Planning and Development Acts 2000 to 2020

Planning Authority: Fingal County Council

Planning Register Reference Number: FS5/007/20

WHEREAS a question has arisen as to whether the construction of a garden room/gym to the side of the existing dwelling at Rose Cottage, Brackenstown Road, Swords, County Dublin is or is not development or is or is not exempted development:

Proposed Site Layout Plan

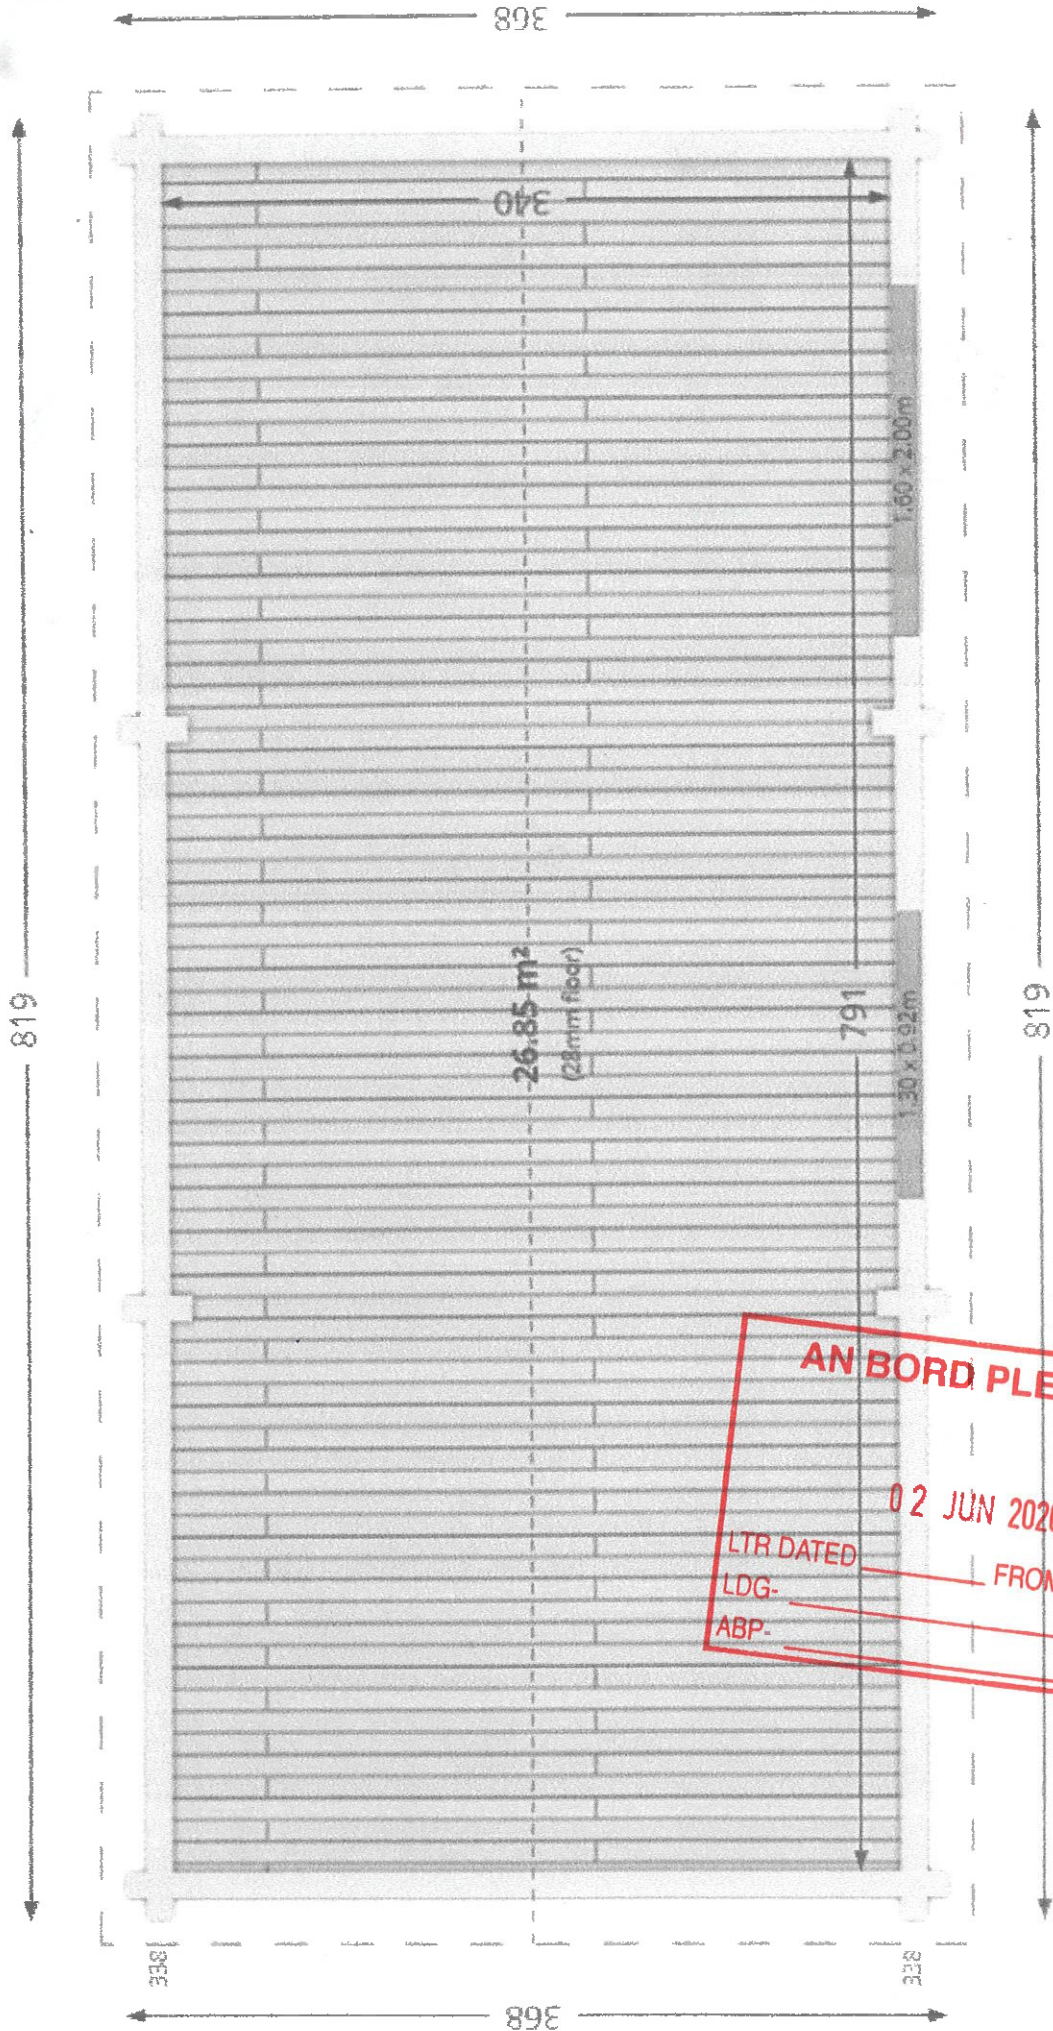
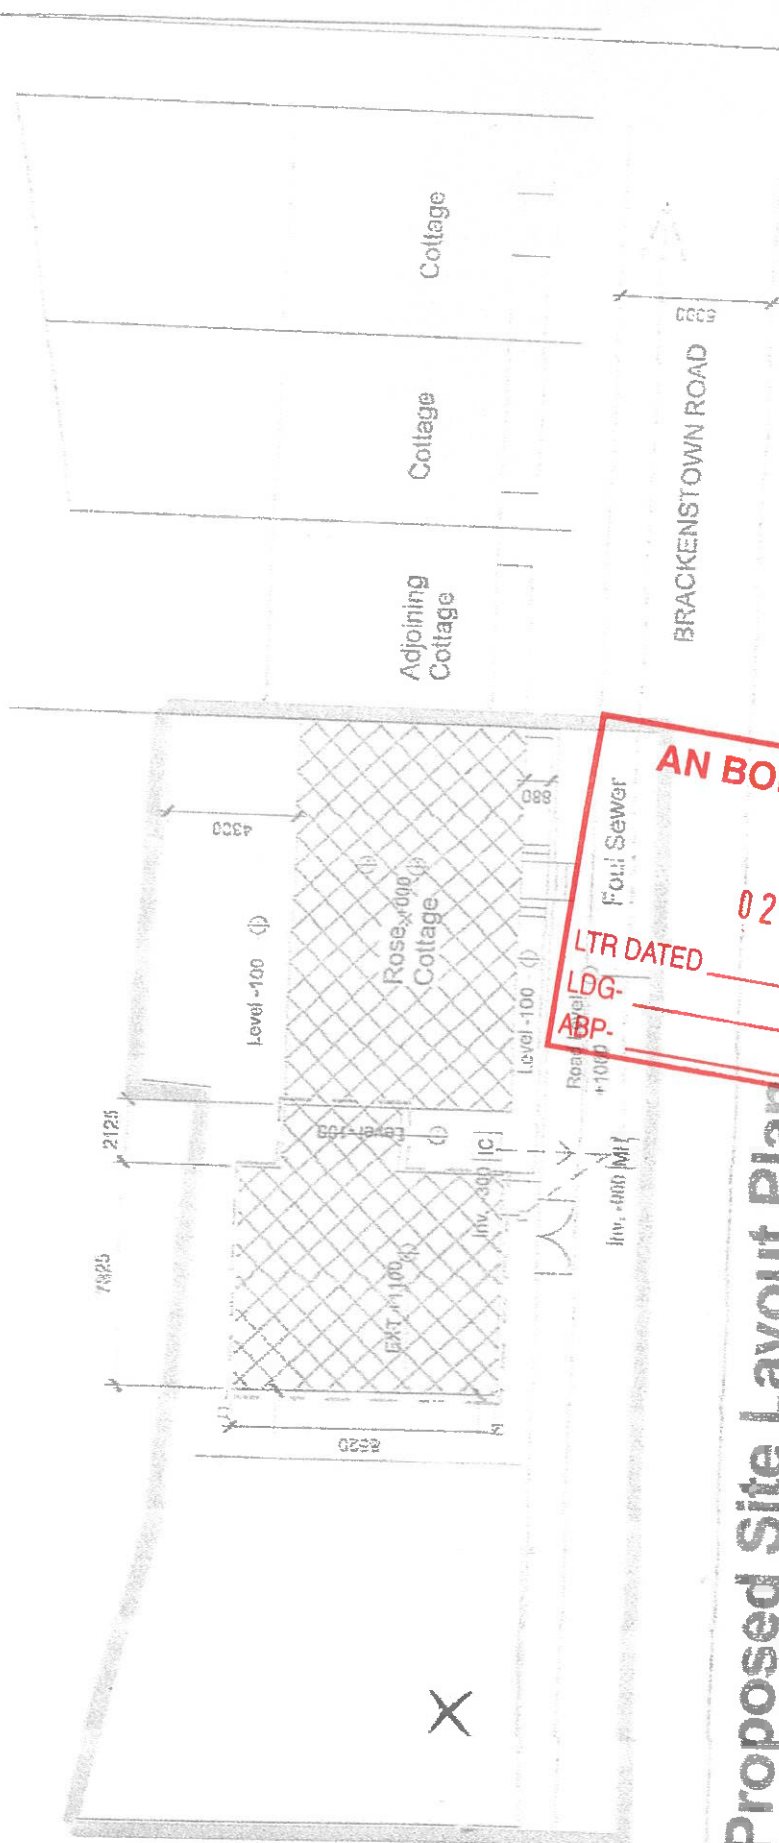
In addition, the Board considered that in the absence of a definitive drawing showing the precise position of the proposed structure within the site and by specific reference to the front wall of the existing house, that it cannot be stated definitively from the wording of the referral itself and the associated documentation presented by the referrer, that it cannot be determined that the proposed structure would be exempted development.

NOTE: Hand-Drawn Plans

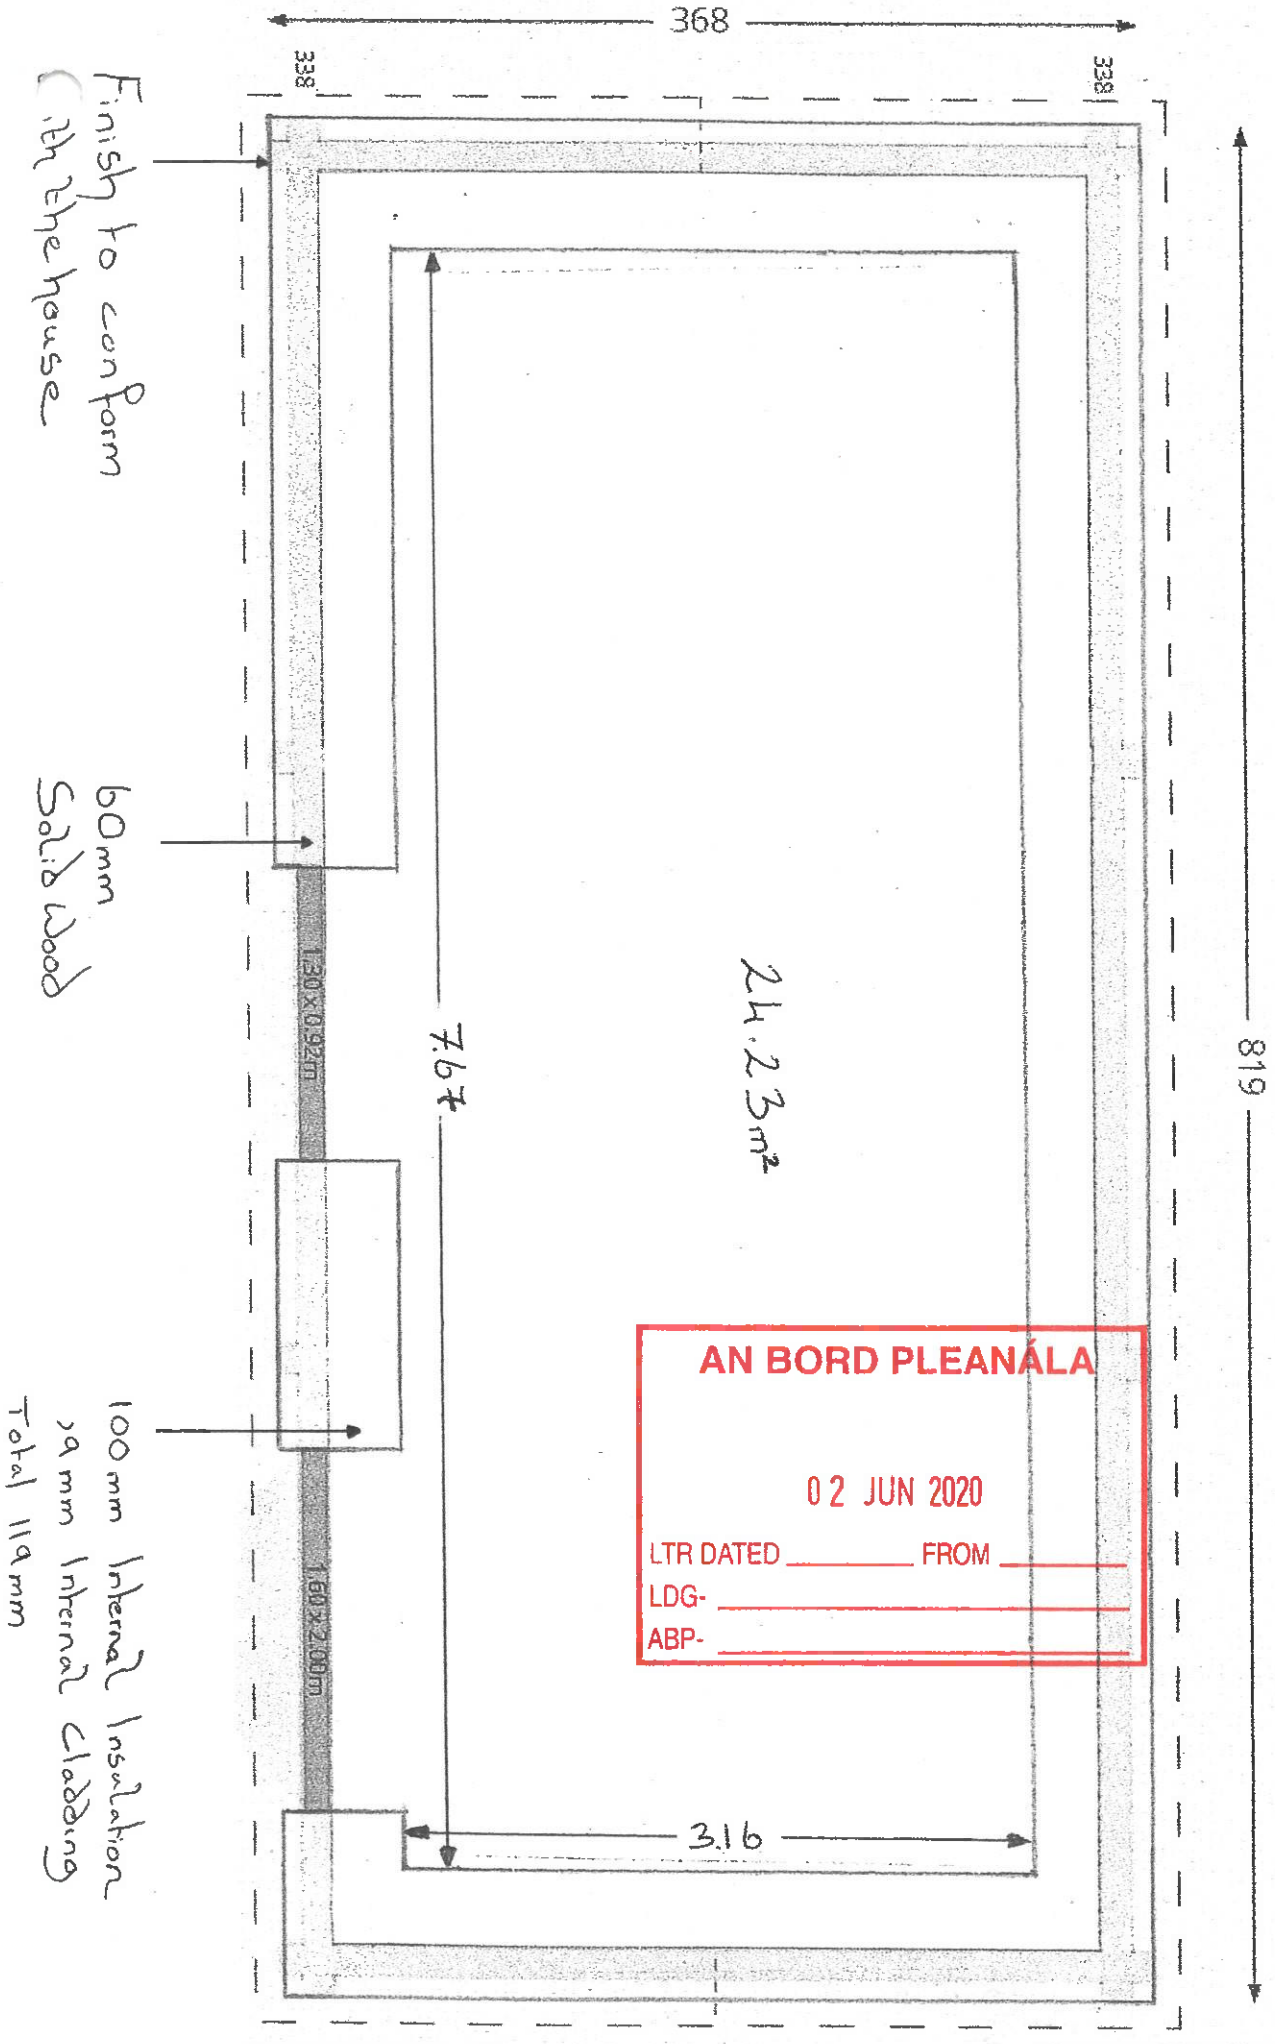
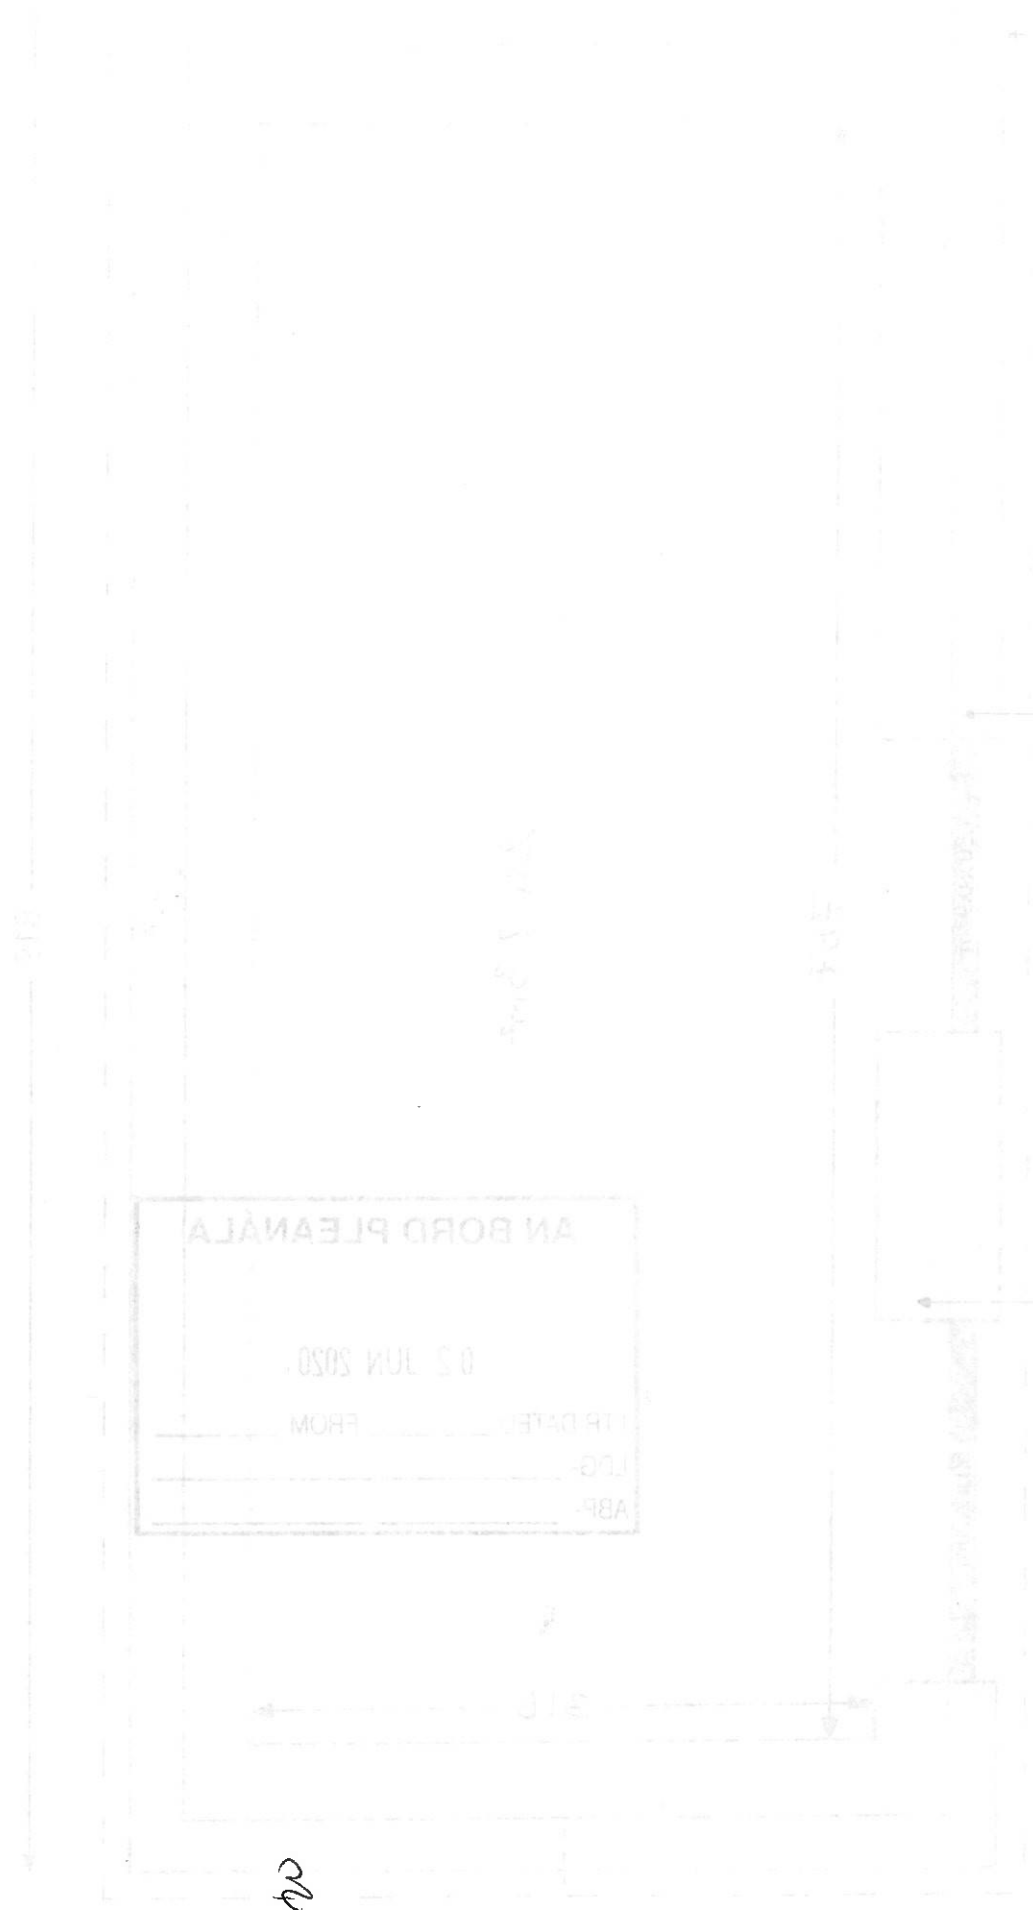
In deciding not to accept the recommendation of the Inspector, the Board considered the totality of information on the file, including the drawing detail submitted by the referrer and noted the commentary of the Inspector on matters relating to the external finishes and roof covering, and the height of the proposed structure, specifically that these are 'open to question'. In this regard, the Board considered that the limited information submitted with the referral does not allow for a determination that the proposed structure would definitively satisfy the relevant conditions and limitations of Class 3.
